Our Ref: AW/90/11/

Rear single storey extension and first floor side extension
3 Willow Way Bognor Regis West Sussex

I regret that I am unable to accept your documents as a formal application until the following matters have been resolved :-

PROPOSED FIRST FLOOR PLAN

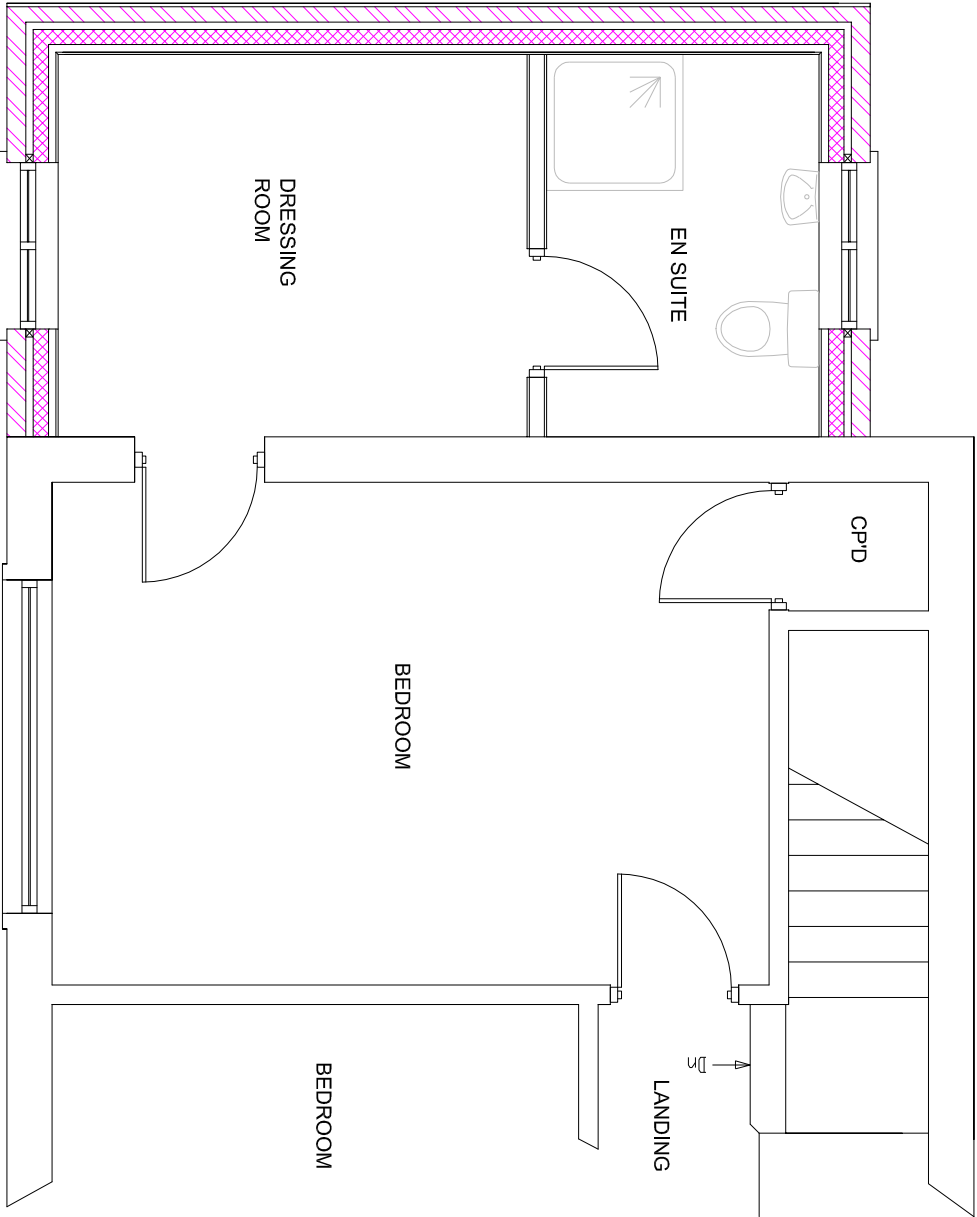
Please provide 1 electronic or 3 paper copies of Existing and Proposed first floor plans.

PROPOSED GROUND FLOOR PLAN

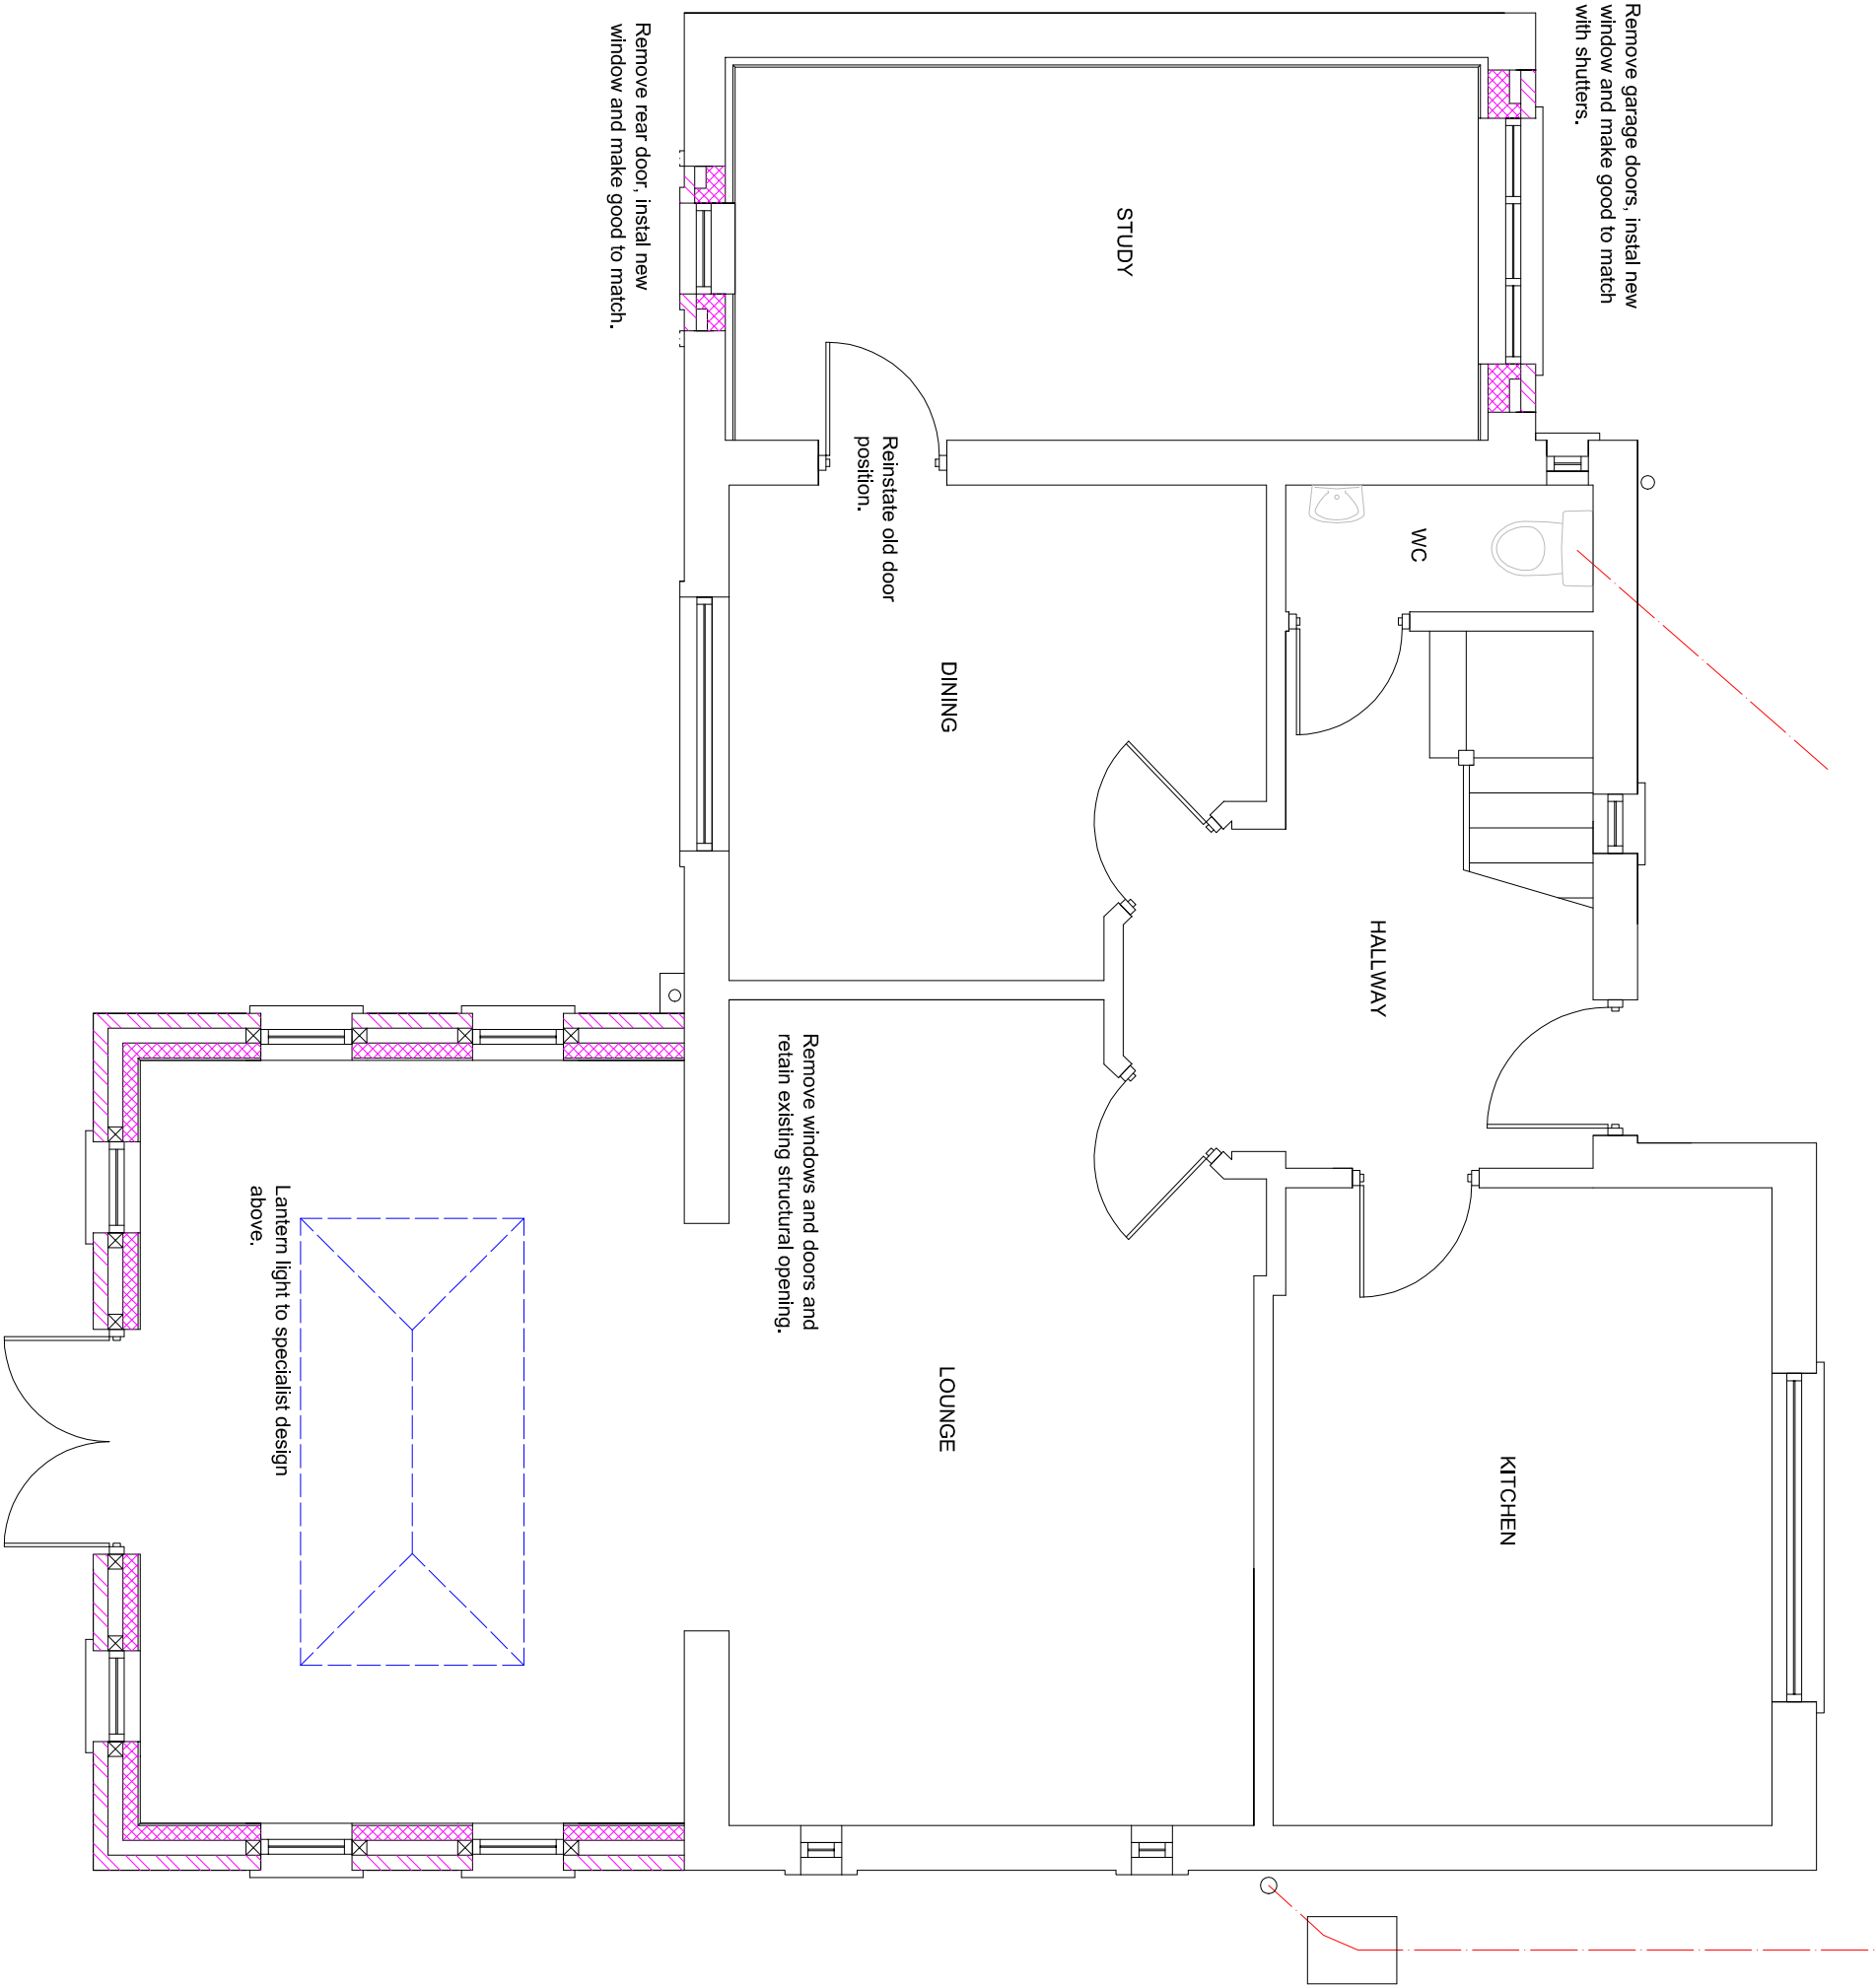
Please provide 1 electronic or 3 paper copies of revised existing and proposed floor plans at a scale of 1:50 to show the WC window and the kitchen windows in accordance with the guidance notes available on our website detailed below (click on National List).

There are two sets of plans which are named Ground floor plans. The ones that include the balcony and bedrooms do not appear to match up with the elevations, please could you clarify.
